**DRB CASE NO/PROJECT NO: 1004873**

Site Plan for Building Permit

DATE: October 9, 2007  
TO: Sheran Matson, DRB Chair  
FROM: Catalina Lehner, Senior Planner   
RE: Project #1004873, Mesa del Sol Community Center Building A

The Site Development Plan for Building Permit (dated September 25, 2007) does not satisfactorily meet the EPC conditions as elaborated in the amended Official Notification of Decision (June 15, 2007) for the following reasons:

SHEET NUMBER: 7 of 7

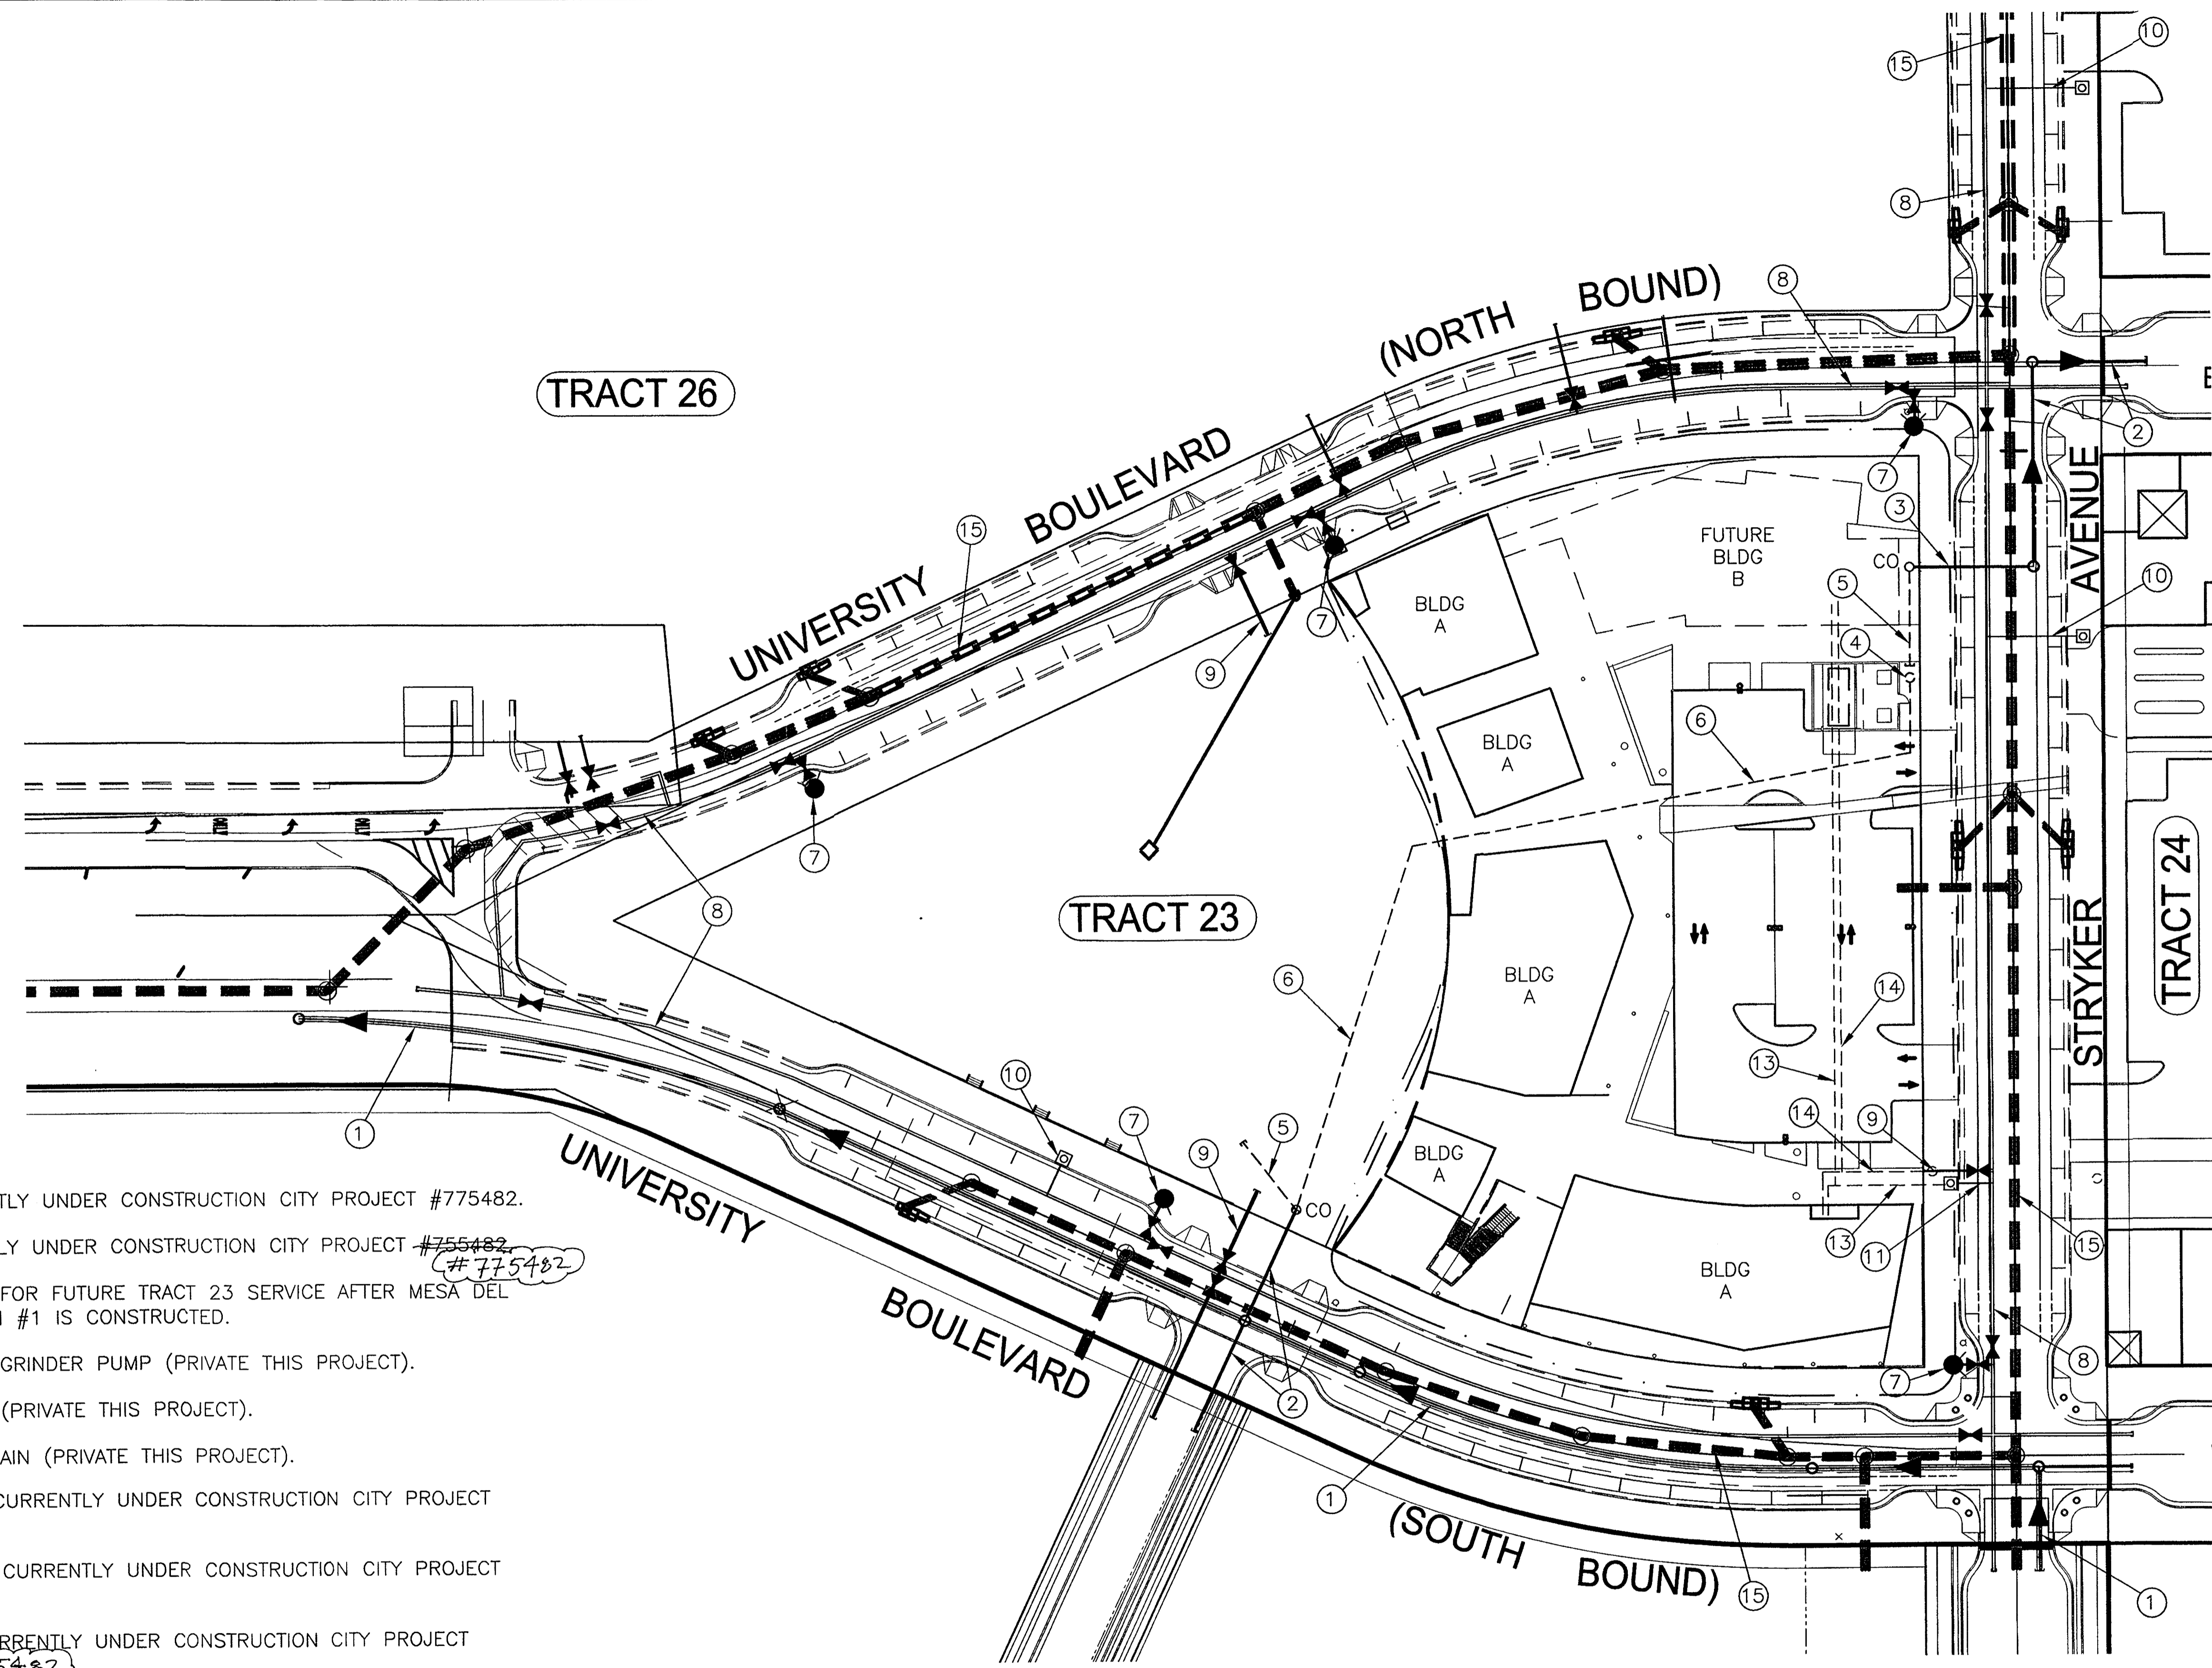
PLANNING (Last to sign): Catalina's initials J.E.  
 Scarpis  
 note 2, 9, 10 & 11 of Utility Plan.  
 \_\_\_\_\_  
 \_\_\_\_\_
